**WEST SUSSEX COUNTY COUNCIL
STRATEGIC PLANNING CONSULTATION**

SUBJECT: EP/95/12/A - 3 x externally illuminated fascia signs, 1 x non-illuminated hanging sign, 4 x lockable poster cases & digitally printed vinyl graphics to window glazing.

One Stop Community Stores Ltd, 135, North Lane, East Preston, West Sussex, BN16 1HB

Proposed Site Signage

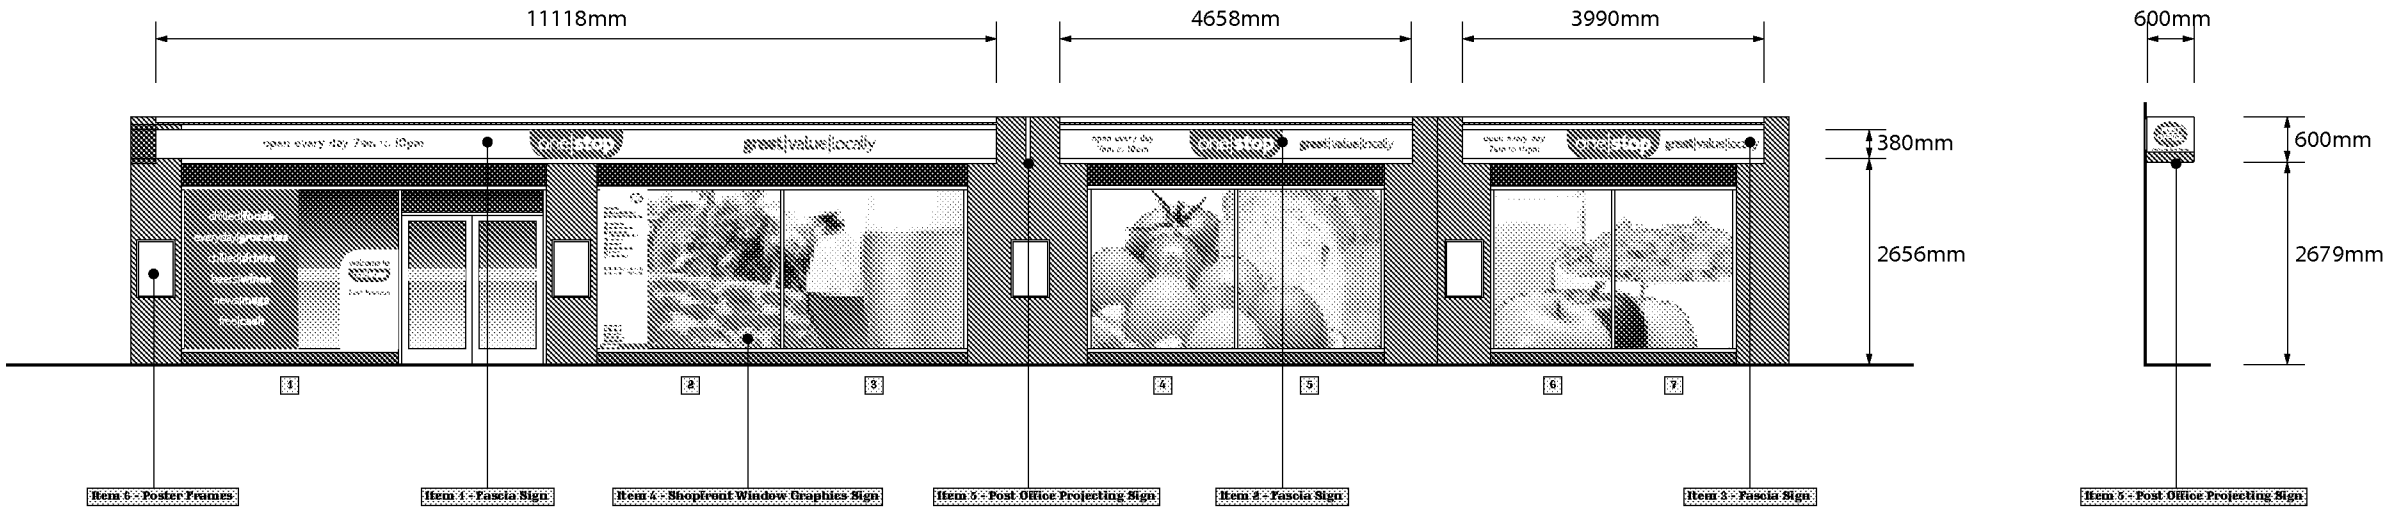
Upon inspection of the plans, it does not appear that these signs will be placed in locations where they could obstruct the highway.

The proposed luminance levels of 250 cd/m² do not exceed recommendations made by the Institute of Lighting Engineers for illuminated signs in locations such as this. As the projection sign overhangs the public highway the applicant must contact WSCC to obtain a Section 177 Licence.

Council (Tel no: 01243 642105 or email street.works@westsussex.gov.uk) to obtain a Section 177 Licence under the Highways Act 1980 to cover any structure that overhangs the highway.
